Araluen Progress Association (APA) Submission  
in respect of the adequacy of  
the Dargues Reef Gold Project (PA 10\_0054)  
Environmental Assessment (EA) report.

**Figure 7 Number of Days in Each Modelled Year when Harvestable-Right Dams Ran Dry.**

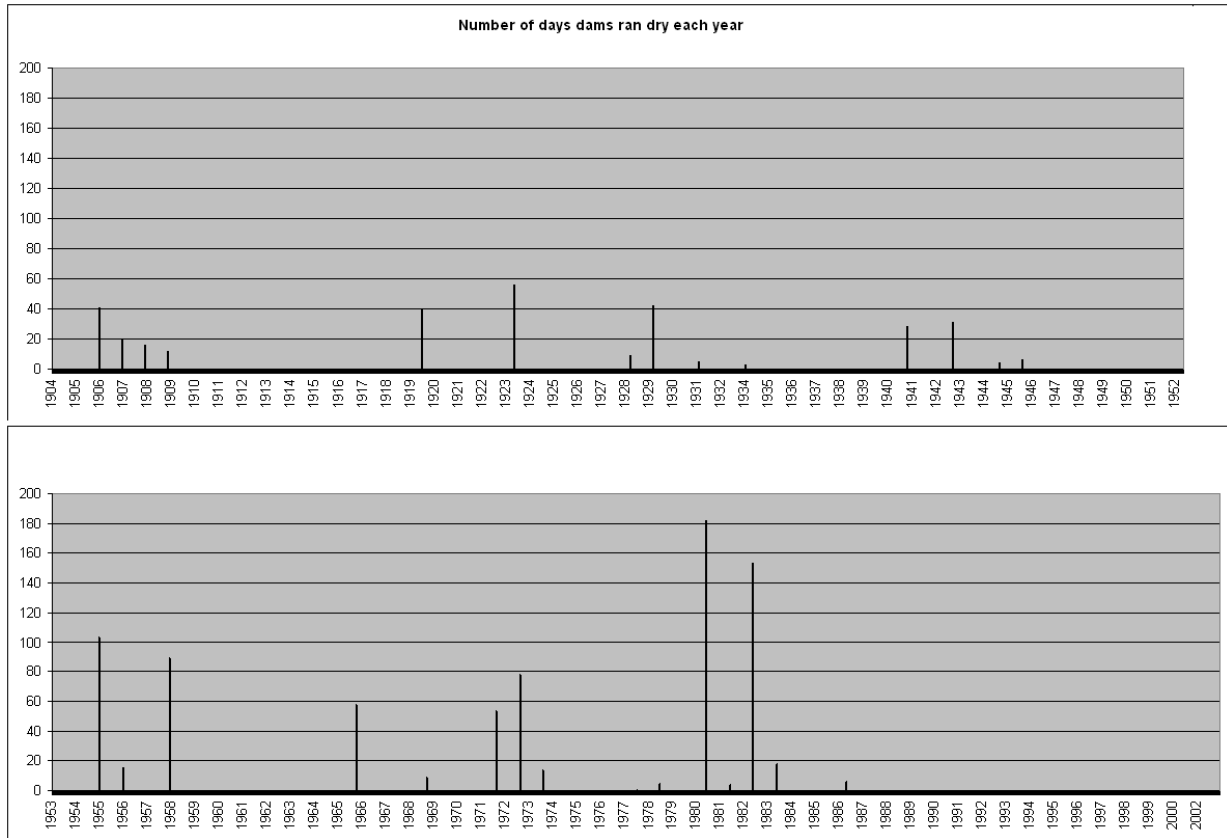
The driest year on record (*100 year data*) would indicate by the EAs own assessment that the harvestable water would not be available for 182 days of that or similar years. Given the weather data does not include run off predictions projected in light of climate change issues this is also not an adequate response. Several drought years would indicate a significant impact on environmental flows.

**APA request** a review and re-submission of an improved approach to the Harvestable Rights issue, evidence that the climate change projections have been considered and contingency plans for reduction of water use within the operation if environmental flows are not available. We would also like to see some evidence that NSW Water has been consulted on this issue prior to a decision being made. This would appear to be best practice.
